City of Portland, Maine – Building or Use Permit Application 389 Congress Street, 04101, Tel: (207) 874-8703, FAX: 874-8716

Location of Construction: 15 17 Liberty Way (Lot 16 the Pines)		Owner: Pines of Portland, Inc.		Phone: **** 772-2127		Permit No: 000883
Owner Address: N/A		Lessee/Buyer's Name: Pines of Portland		BusinessName:		
Contractor Name: Pines of Portland, Inc.		Address: 426 Forest Ave. Portland, ME		Phone: 04101		Permit Issued: AUG 1 2000
Past Use: Vacant		Proposed Use: New Single Family		COST OF WORK: \$ 135,000.00 PERMIT FEE: \$ 834.00 FIRE DEPT. <input type="checkbox"/> Approved <input type="checkbox"/> Denied INSPECTION: Use Group A-3 Type: 5B Signature: <i>[Signature]</i> Date: <i>[Signature]</i>		
Proposed Project Description: Construction of single family home w/ garage				PEDESTRIAN ACTIVITIES DISTRICT (P.A.D.) Action: <input type="checkbox"/> Approved <input type="checkbox"/> Approved with Conditions <input type="checkbox"/> Denied Signature: <i>[Signature]</i> Date: <i>[Signature]</i>		Zoning Approval: OK with conditions 9/4/00 Special Zone or Review: <input type="checkbox"/> Shoreland <input checked="" type="checkbox"/> Wetland <input type="checkbox"/> Flo

7-18-00
 Lot 16 Pines @ Liberty Way
 Plot Plan Prepared by Greg McCormack
 Reference: Plan of Liberty Way
 Conceptual Grading Plan
 By Pinkham & Greer
 Scale 1" = 30'

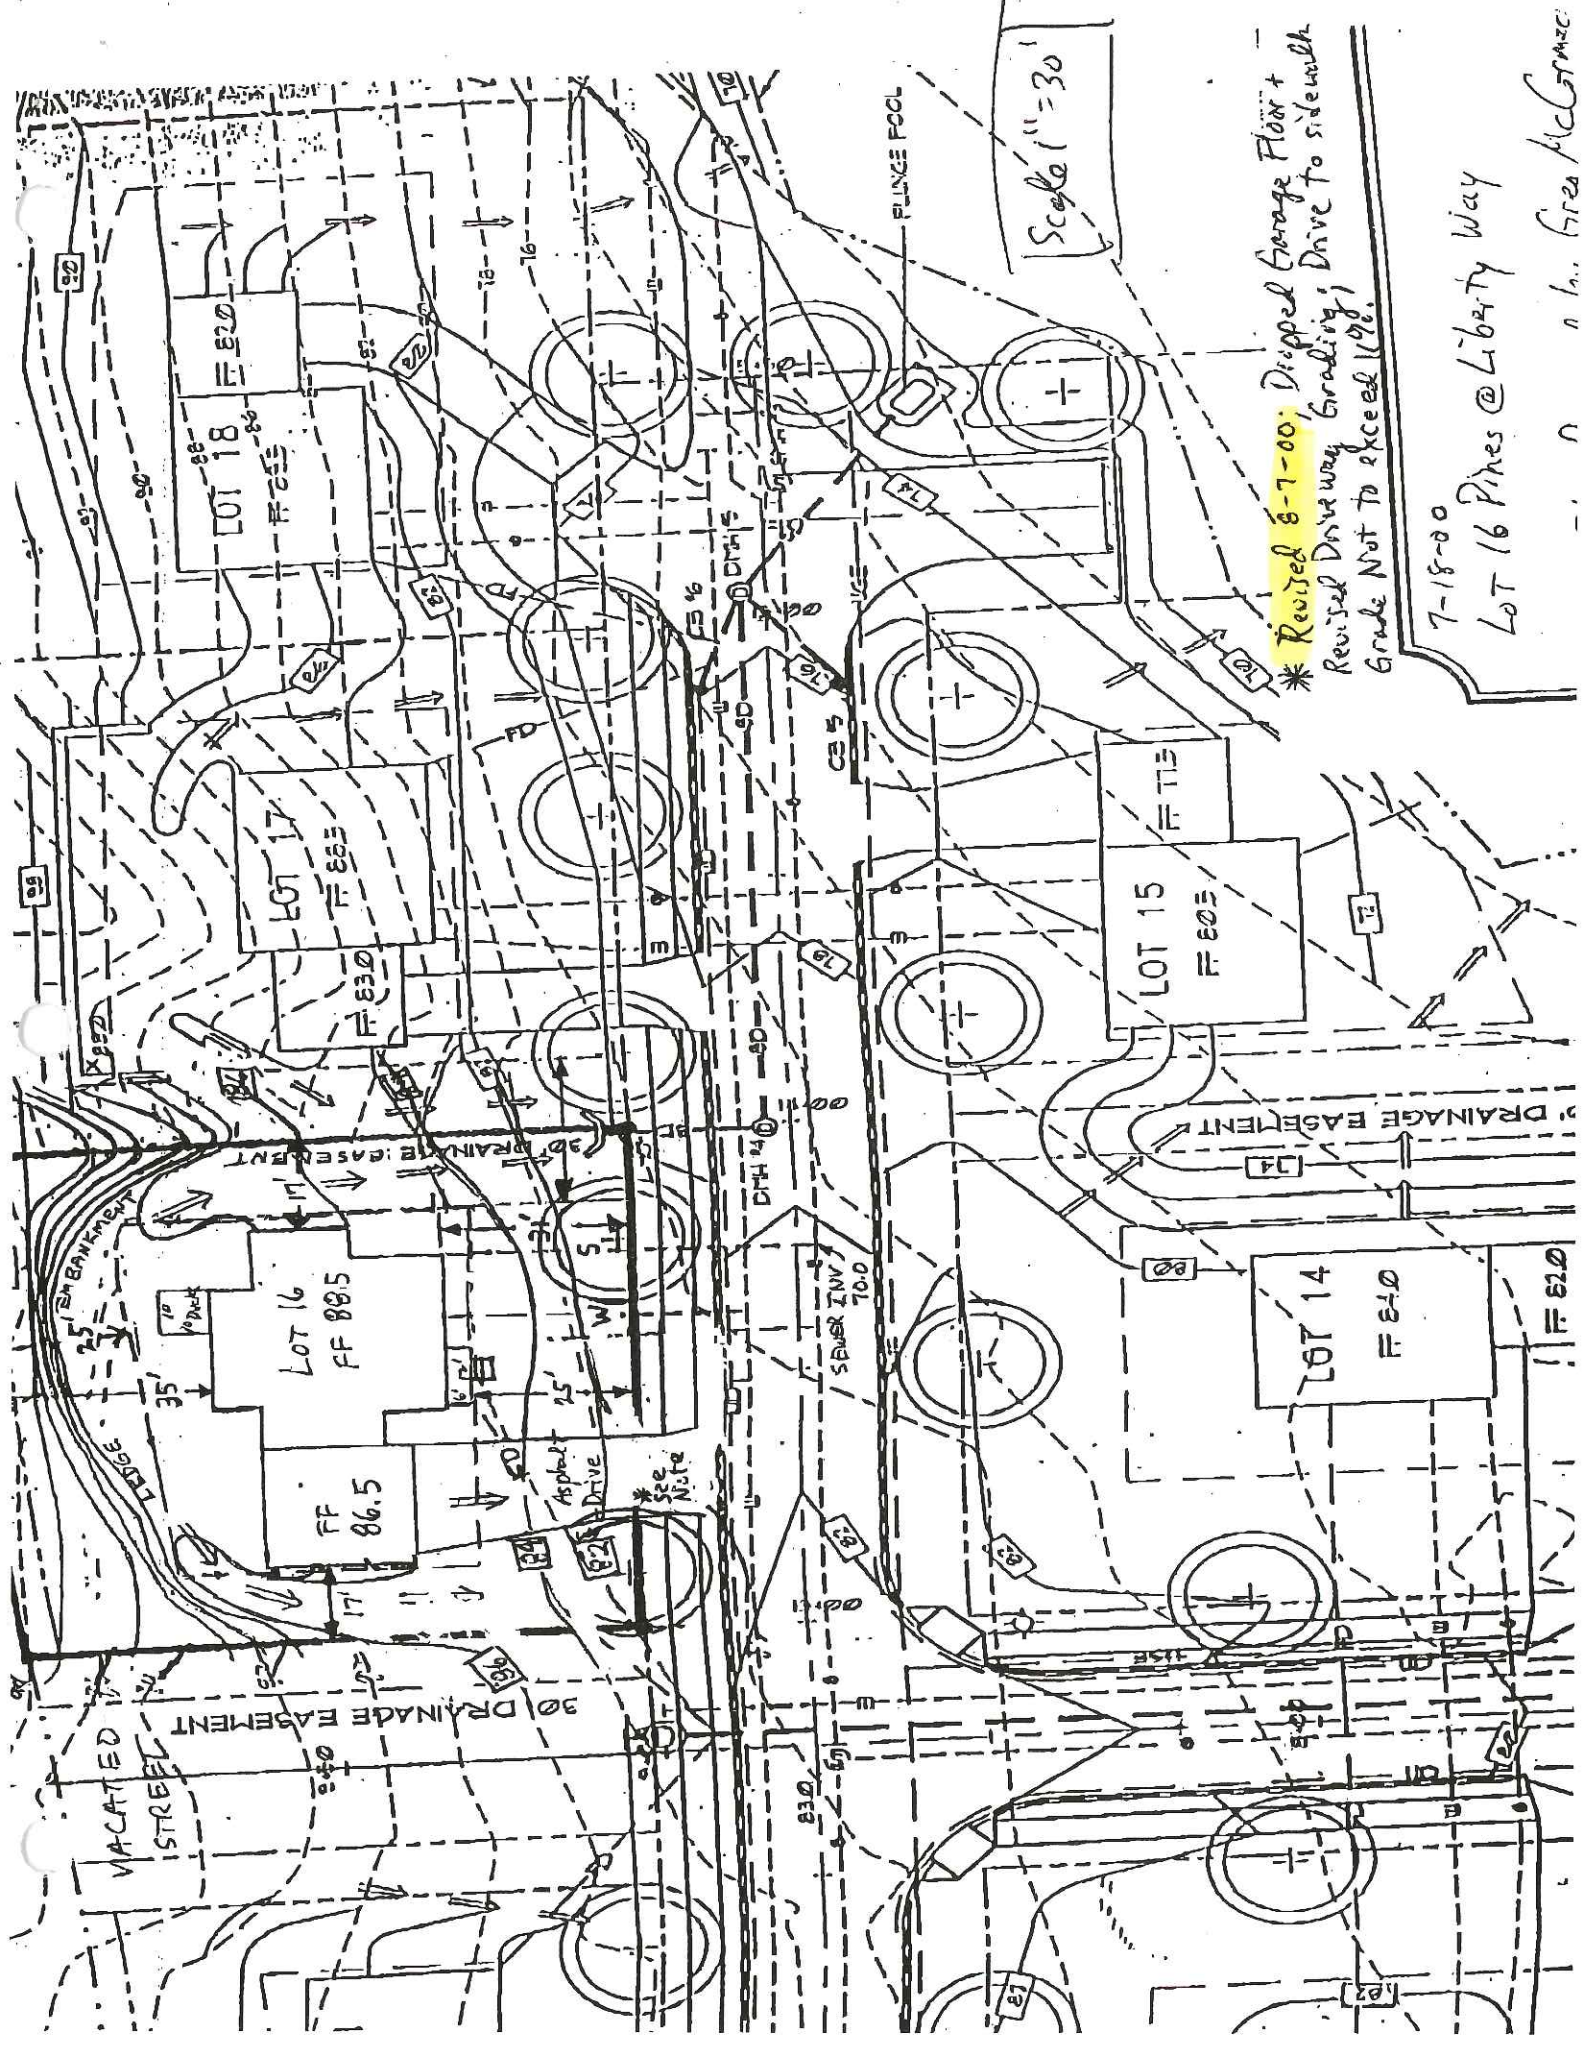
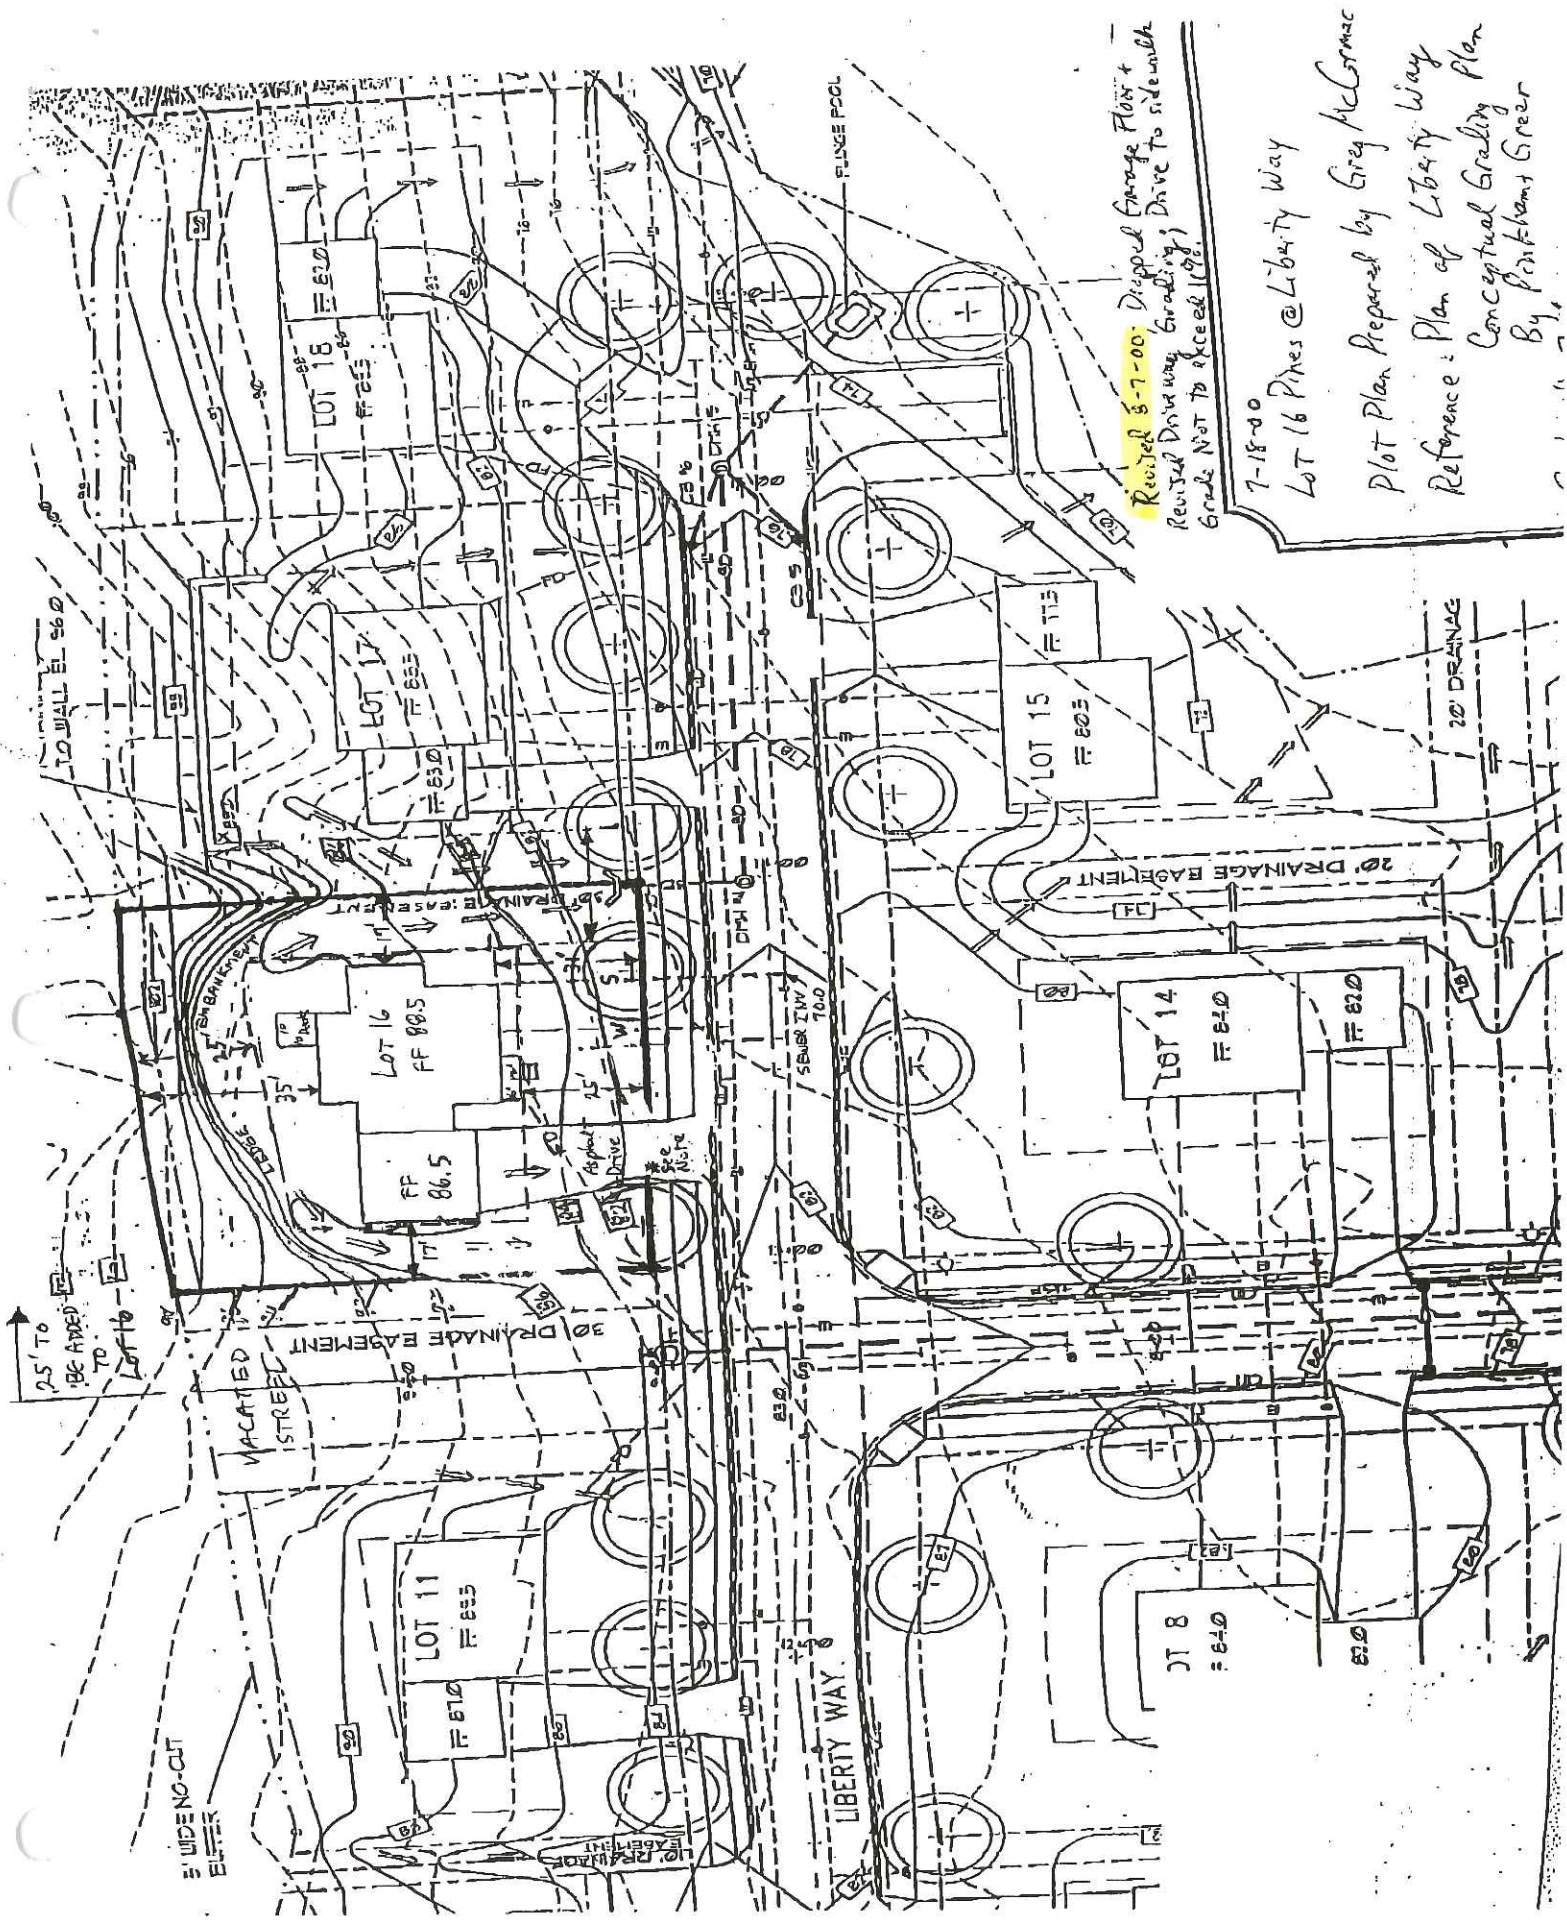
A drainage plan shall be submitted to and approved by Development Review Coordinator showing first floor elevation (FFE), sill elevation (SE), finish street/curb elevation, lot grading, existing and proposed contours, drainage patterns and paths, drainage swales, grades at or near abutting property lines, erosion control devices and locations and outlets for drainage from the property.

Applicant will adhere to grading plan/site revised 8/7/00.
